TO: HON. TONY KELLY, THE MINISTER FOR PLANNING
Parliament House, Macquarie Street, Sydney 2000

15 December 2010

Re: Jones Bay Wharf Marina Development Pyrmont, Jones Bay Wharf, Pyrmont (MP09_0205)

Drawing No.: 3671-02/G

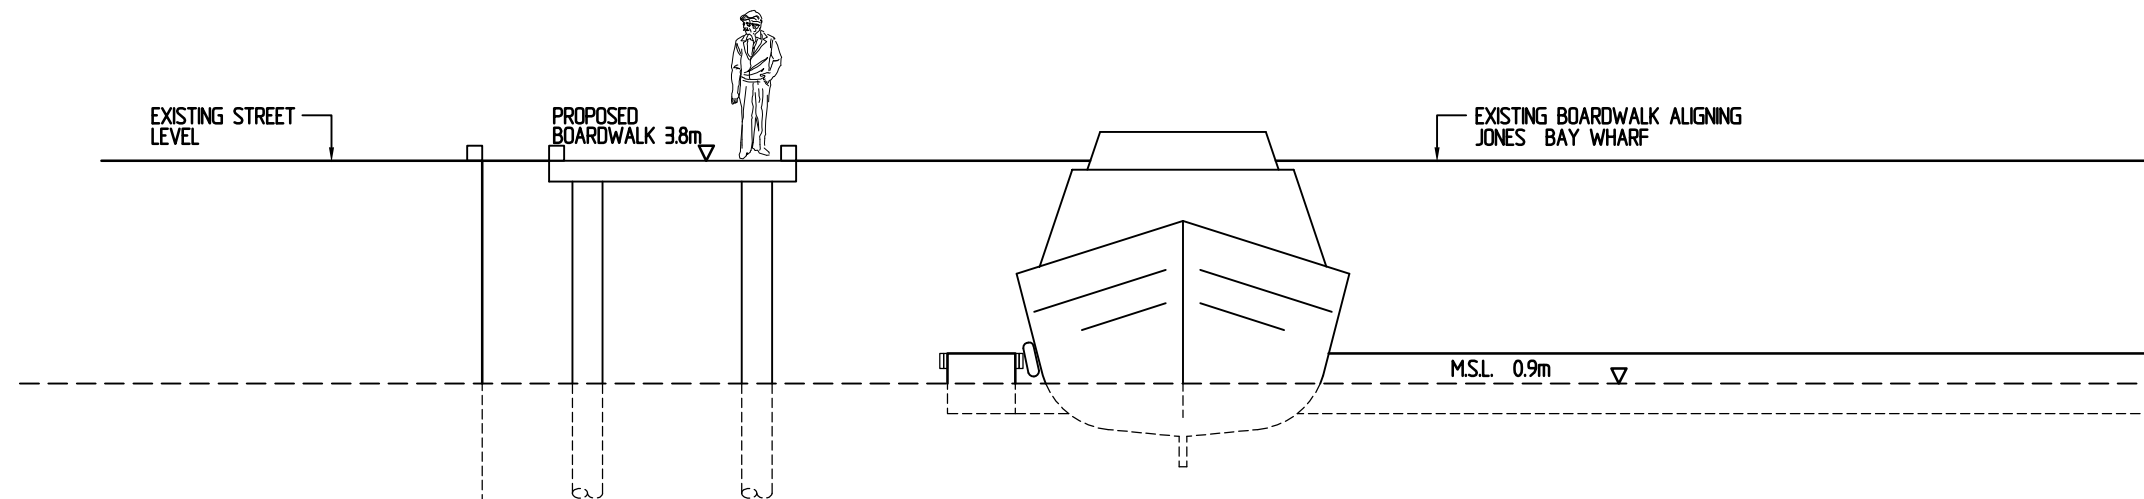
- an increase in vessel numbers from approx. 35 to 73. An estimated $\frac{2}{3}$ of the water within the eastern bay will be covered by vessels/ pontoons and nearly half on the west. The plan provided by developers Toga Development No. 27 Pty Ltd showing the "dynamic" nature of the vessels is incorrect and misleading as current vessels are primarily stationed. This will cause a virtual marine boat park.

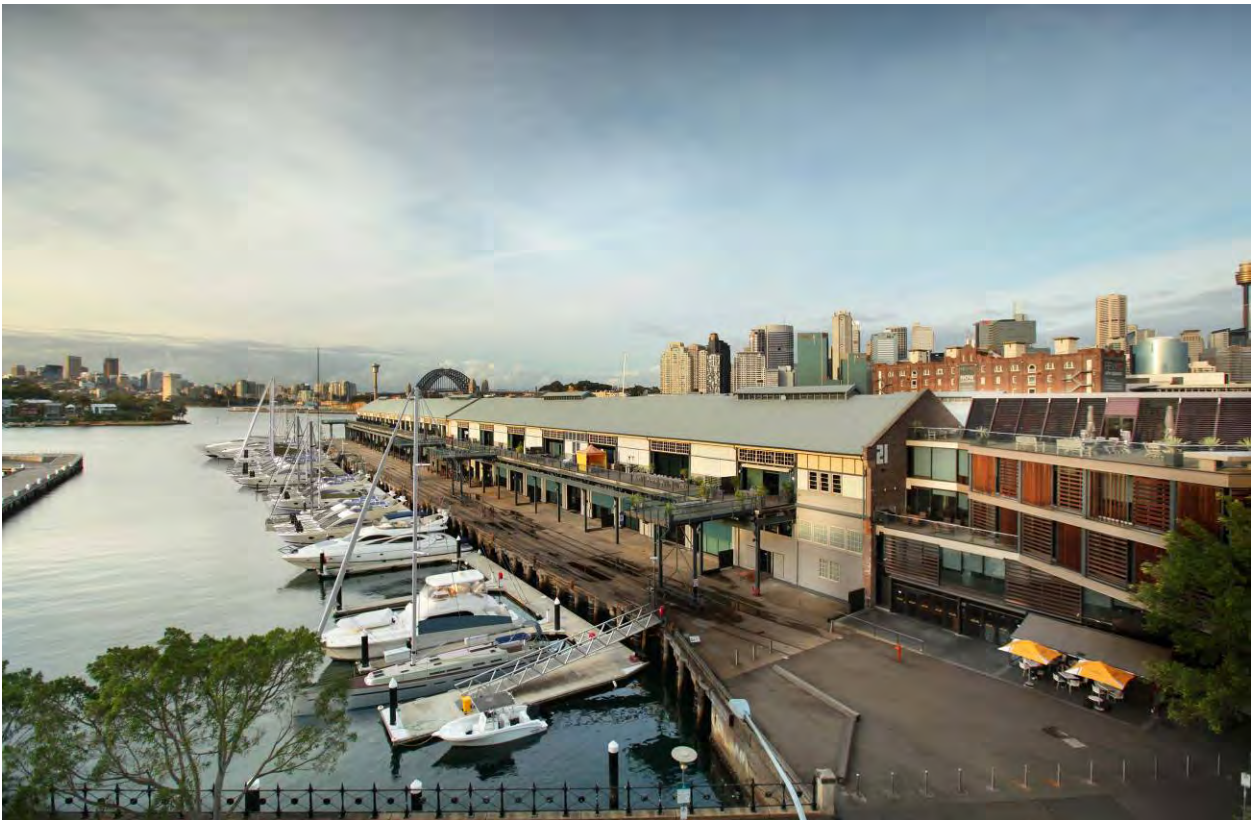
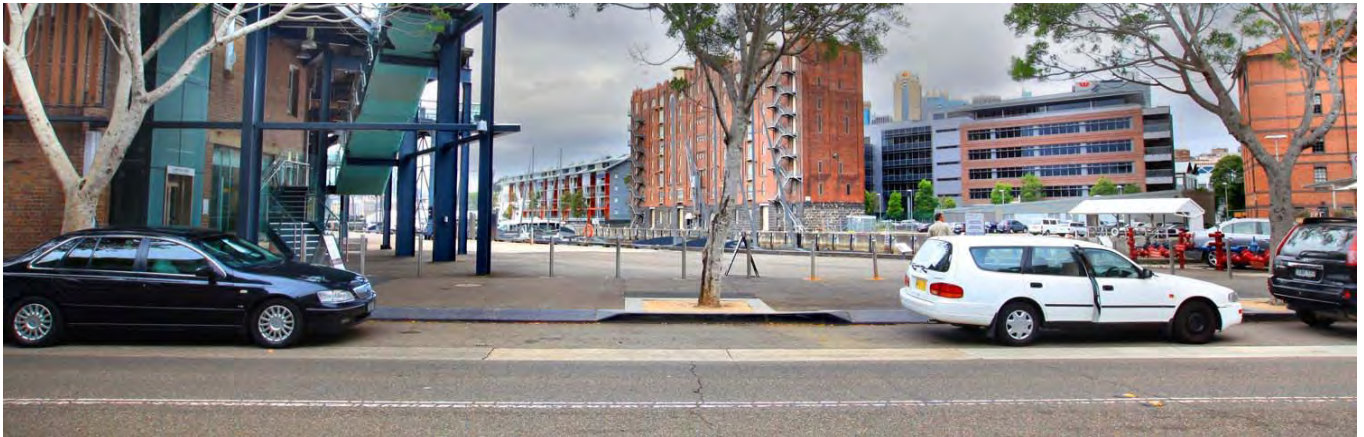
- The impact of the vessels heights and scale on the loss of views from suites and the local area has not been addressed and misrepresented in Toga Development No. 27 Pty Ltd supplied photomontages.
